BRADLEY POINT FILING NO. 1

GRADING/EROSION CONTROL PLANS

BRADLEY POINT FILING NO. 1	
GRADING & EROSION CONTROL PLAN	
PROJECT NO: 70-074	DATE: 11/30/20
DESIGNED BY: VAS	HORIZONTAL: N/A
DRAWN BY: CWV	VERTICAL: N/A
CHECKED BY:	SHEET 1 OF 5
GR01	
212 N. WABATCH AVE. STE 305 COLORADO SPRINGS, CO 80903 PHONE: 719.955.5485	
 CIVIL CONSULTANTS, INC.	
FOR AND ON BEHALF OF M&S CIVIL CONSULTANTS, INC.	
VIRGIL A. SANCHEZ, COLORADO P.E. NO. 37160	
REVISIONS:	NO. DATE BY DESCRIPTION
THE ENGINEER PREPARING THESE PLANS WILL NOT BE RESPONSIBLE OR LIABLE FOR UNAUTHORIZED CHANGES TO OR USES OF THESE PLANS. ALL CHANGES TO THE PLANS MUST BE IN WRITING AND MUST BE APPROVED BY THE PREPARER OF THESE PLANS.	
CAUTION

GRADING AND EROSION CONTROL PLAN

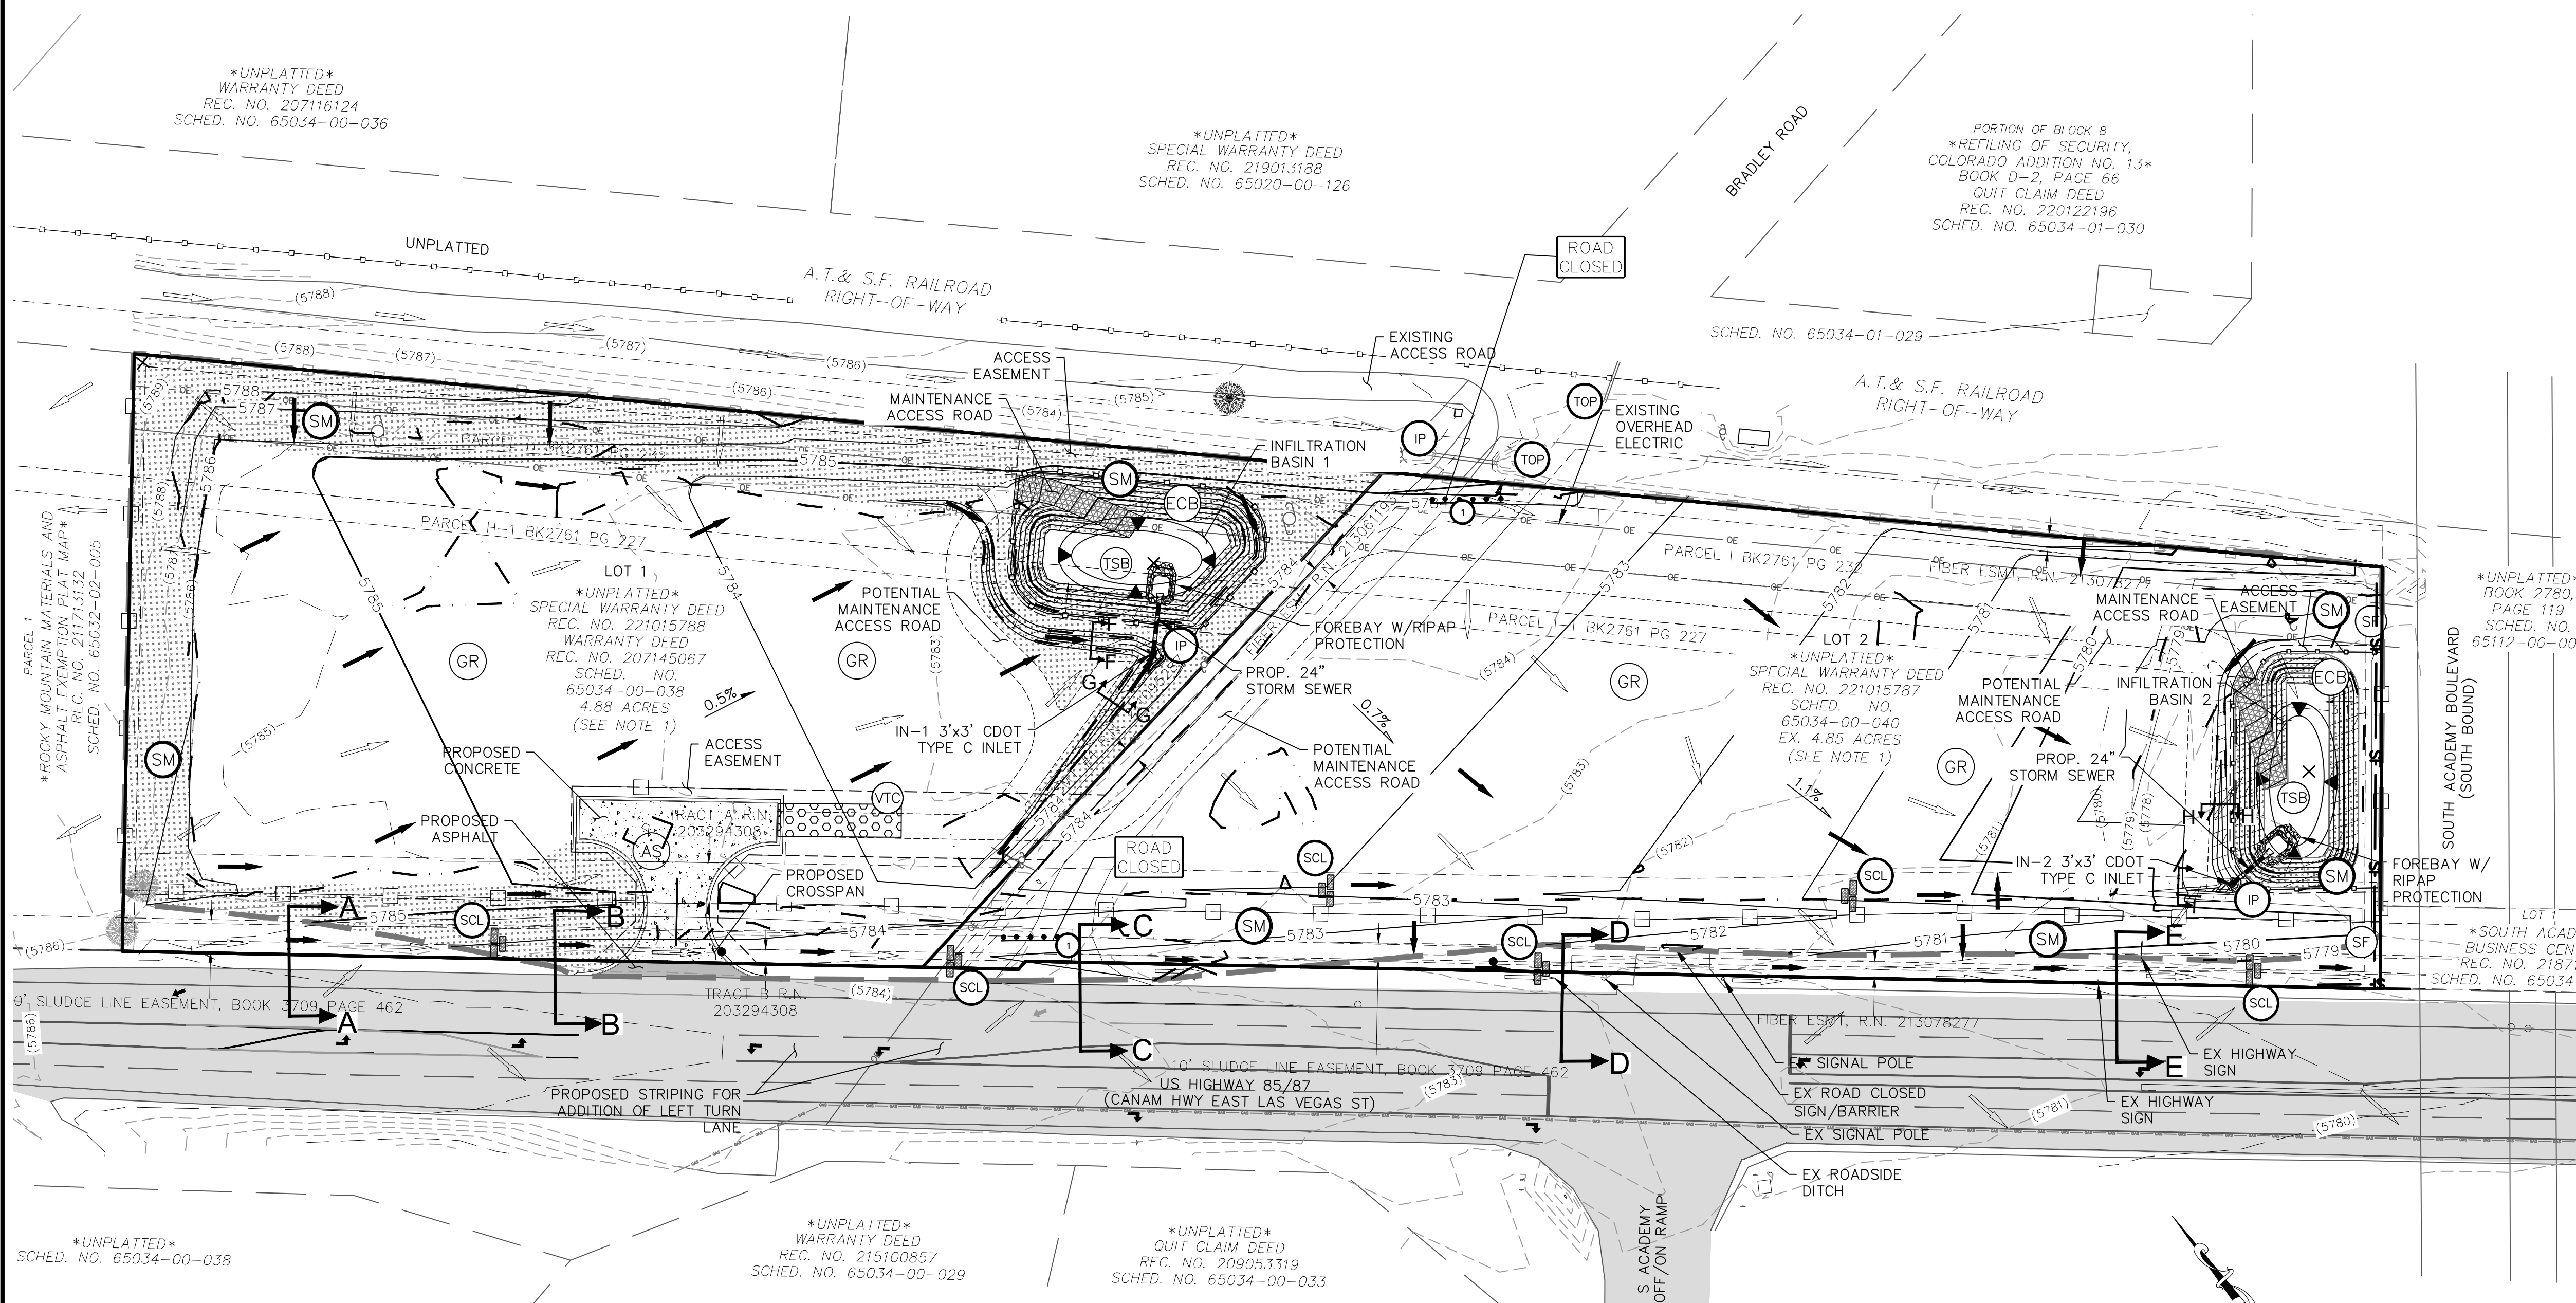
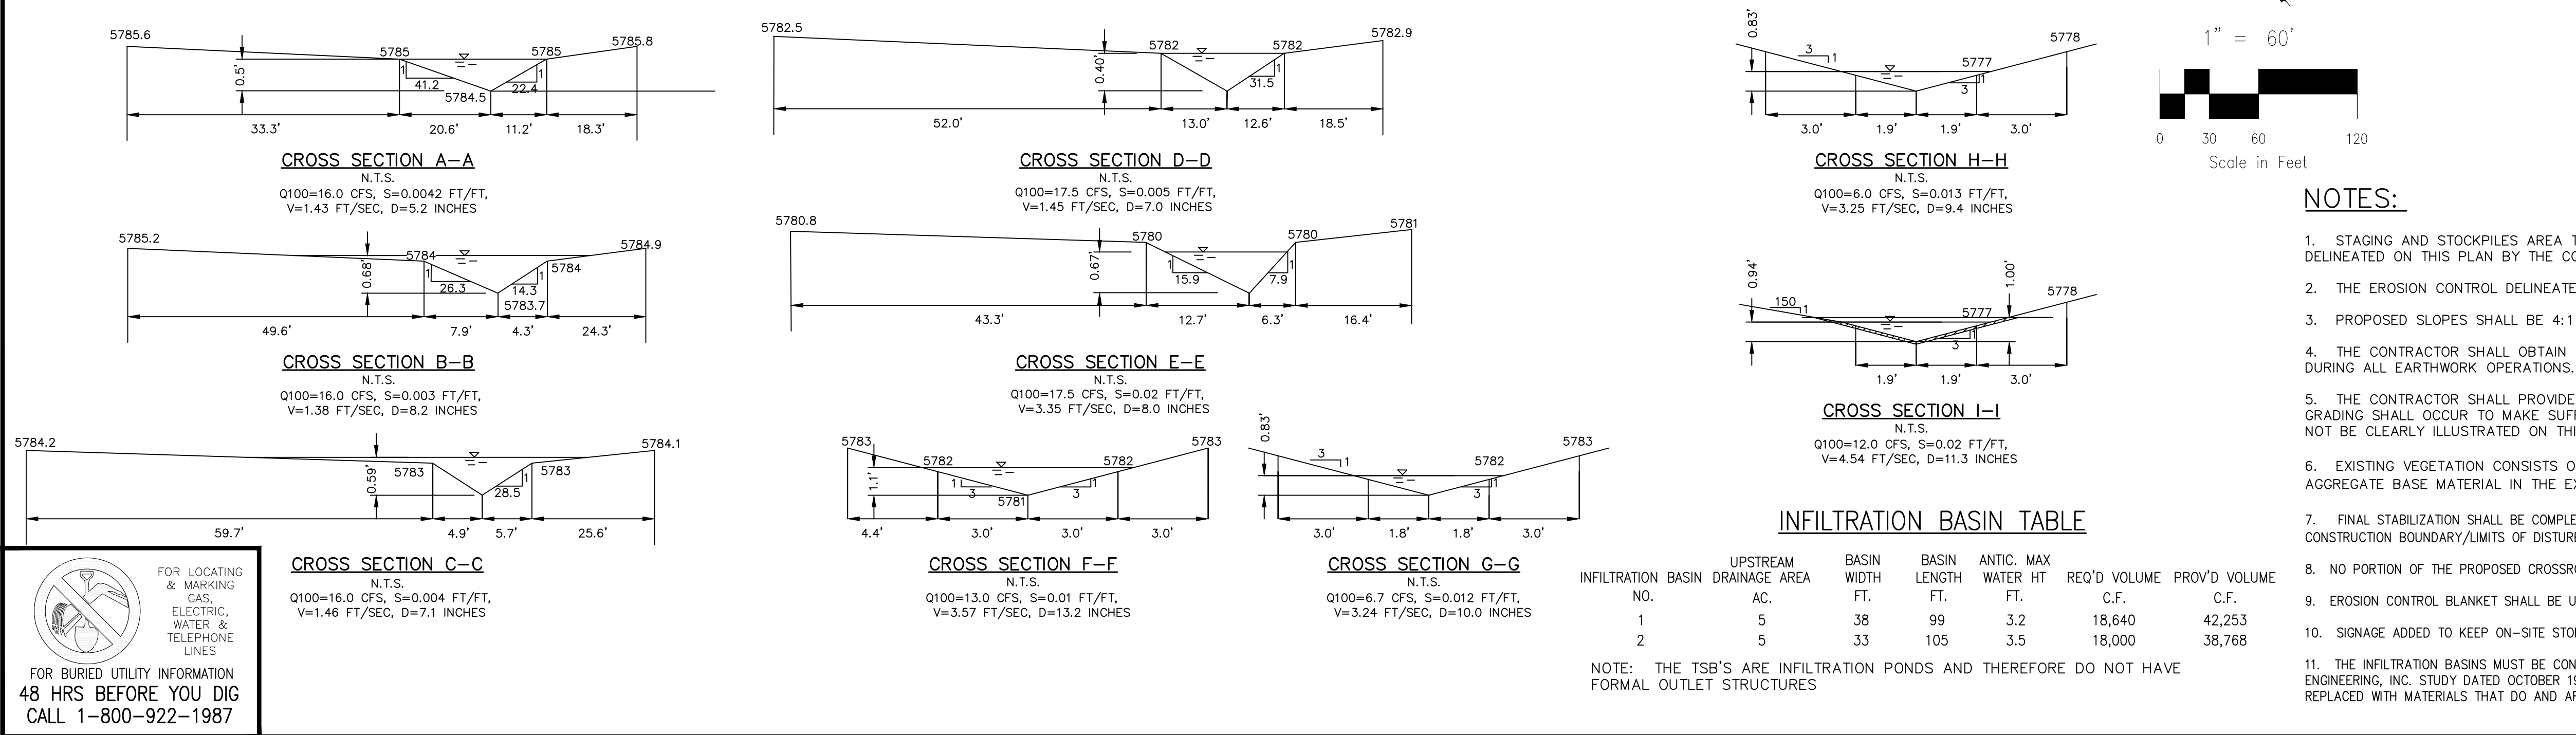
show areas of seeding and mulching
and areas of gravel.

VTC should be initial/interim
REVISED

Add a note about existing vegetation and percent cover.

SILT FENCE ADDED

NO LONGER
GRADING IN
DITCH/SIGN
LOCATION

DOWNSTREAM CONVEYANCE SHOWN
FDR IN EXHIBIT

AREAS OF SEEDING,
BLANKETING, AND
GRAVEL SHOWN

NOTE INCLUDING
THIS INFO ADDED
